CITY OF ALBUQUERQUE

July 31, 2014

**Re: Balloon Fiesta Park Sid Cutter's Pilots' Building
Grading and Drainage Plan
Engineer's Stamp Date 7-2-14 (B17D001F)**

SITE DEVELOPMENT PLAN FOR BUILDING PERMIT  
SITE PLAN

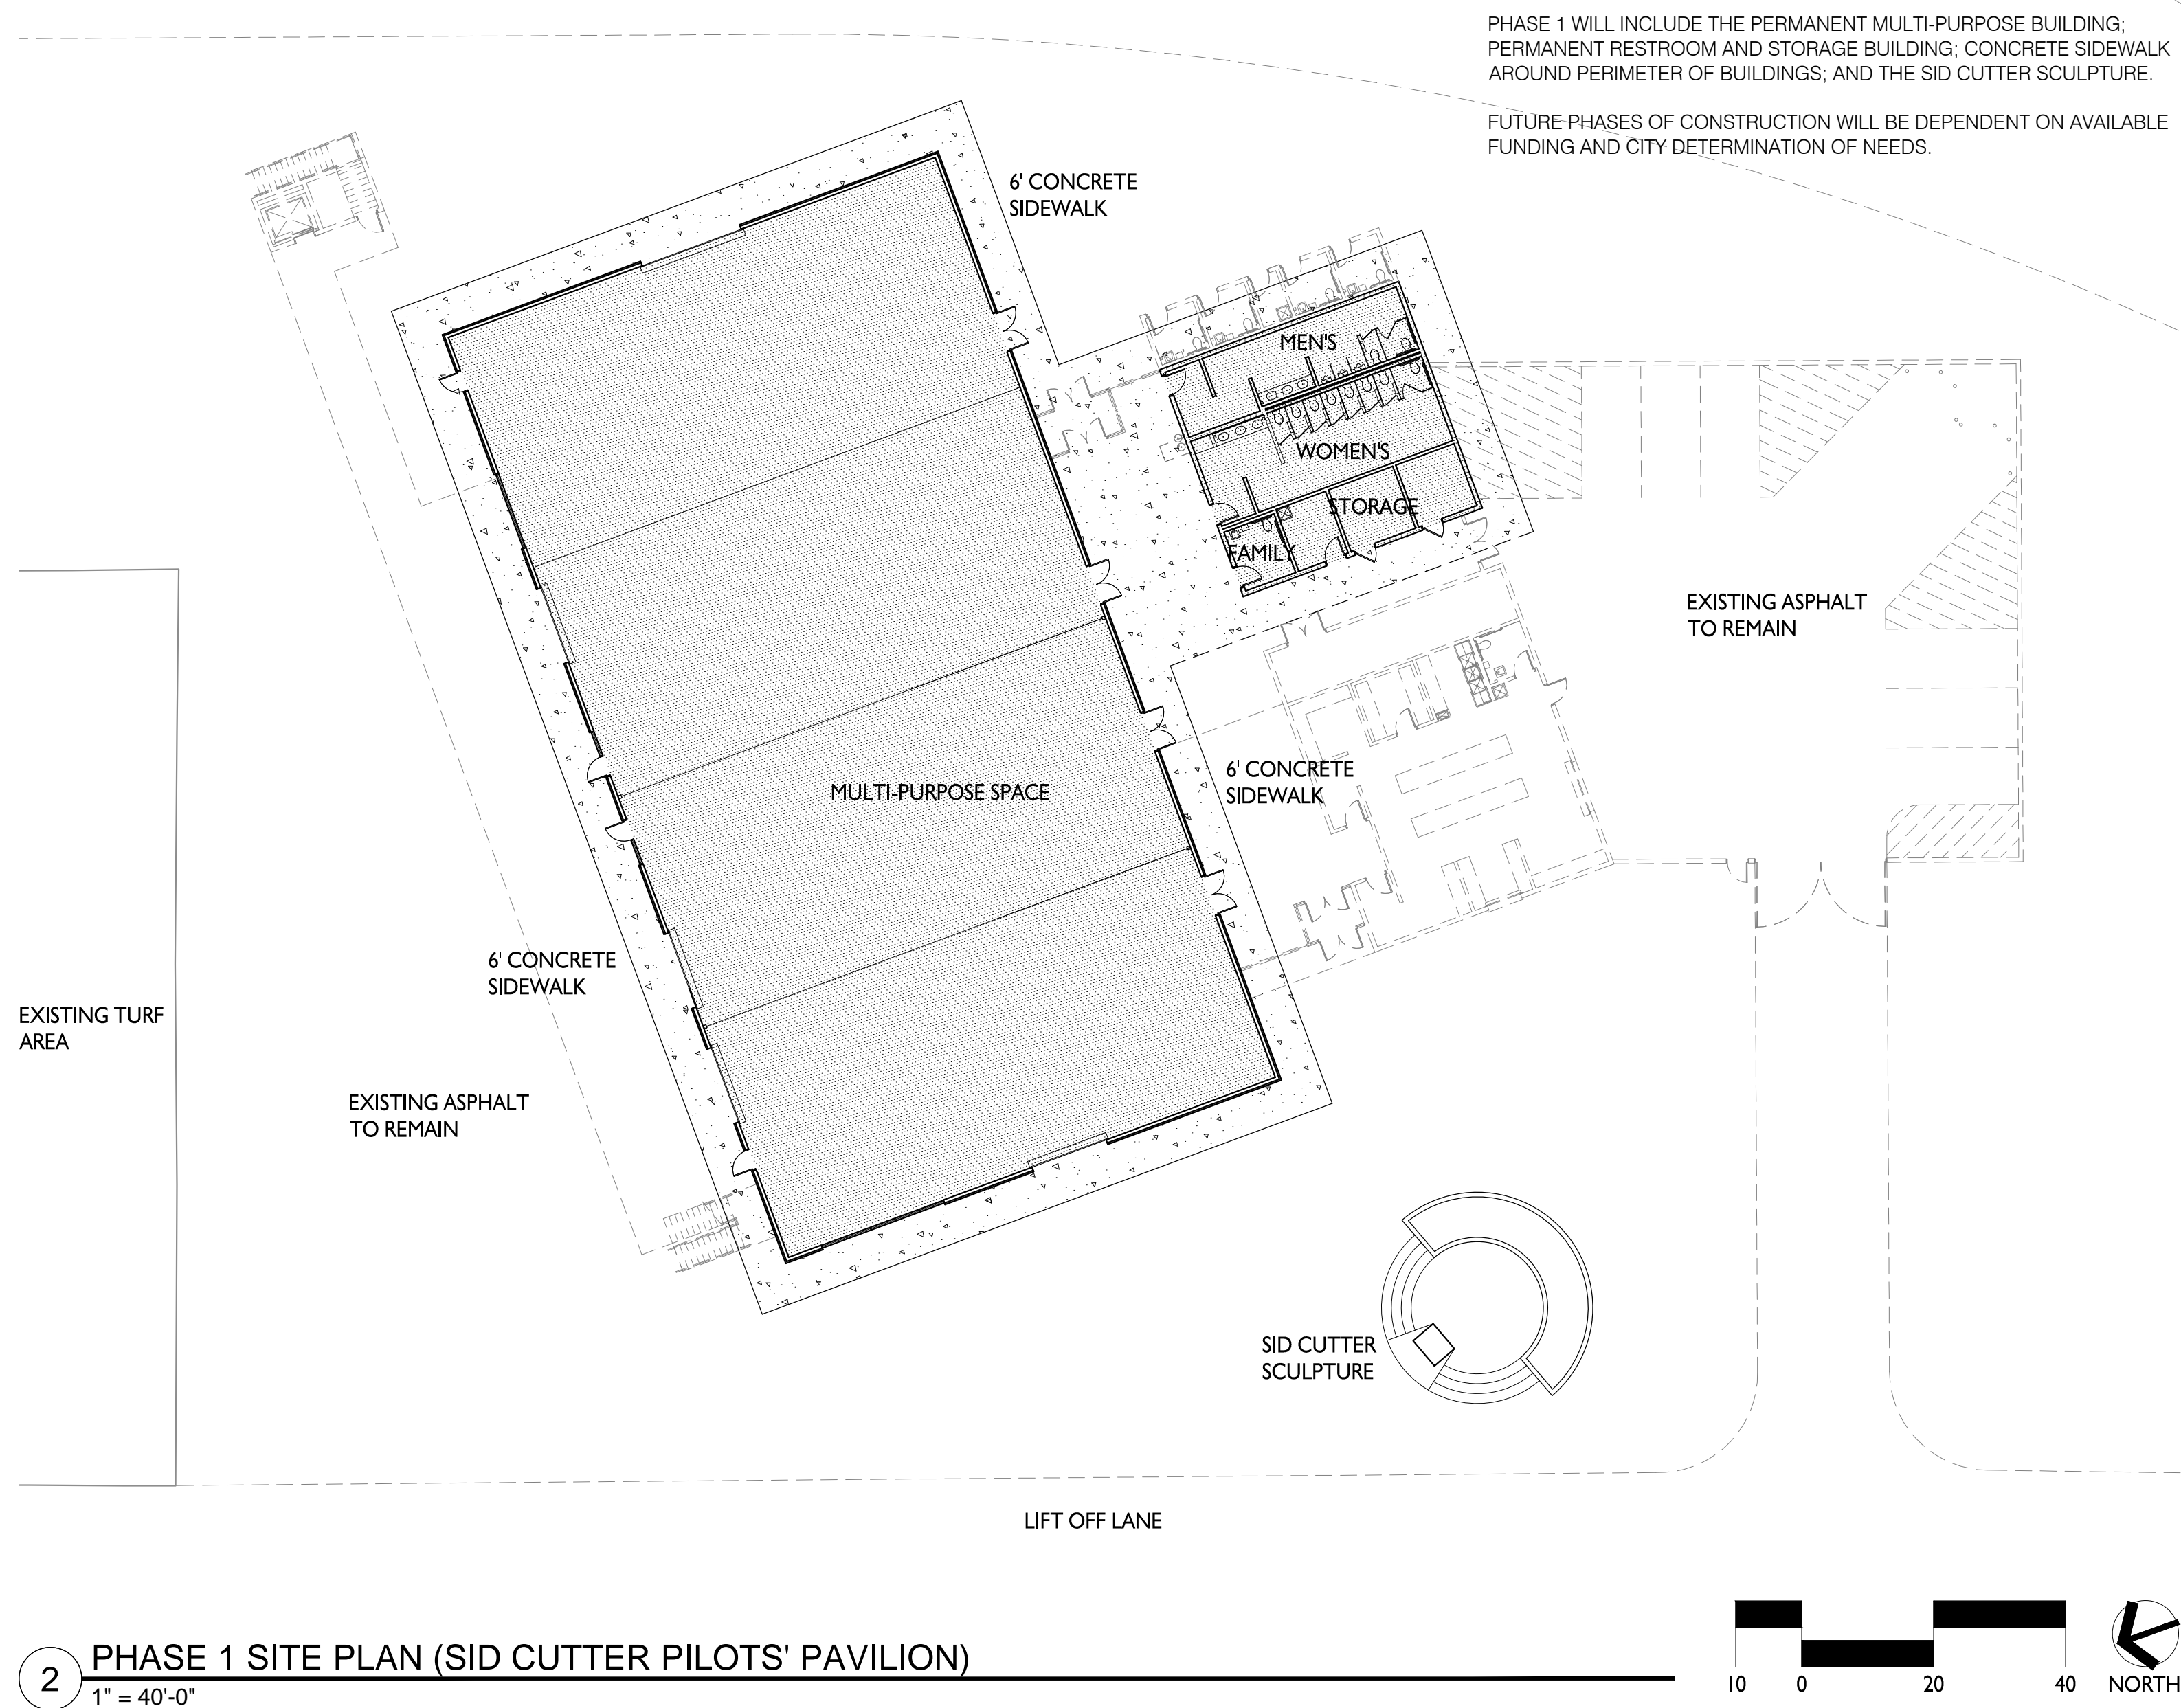
1. The building is different especially on the east side from what was approved for Site Development Plan for Building Permit. What percentage of the building has changed? Has the site plan gone in for an Administrative Amendment? You mentioned a second phase being done for this project. Provide a site plan showing the second phase.

5. Is parking provided? Where are vehicles entering the site? Please show both.
6. For Note 5, specify the type of fitting such as tee and size.
7. Provide pdf electronic copies of signed drawings and calculations.
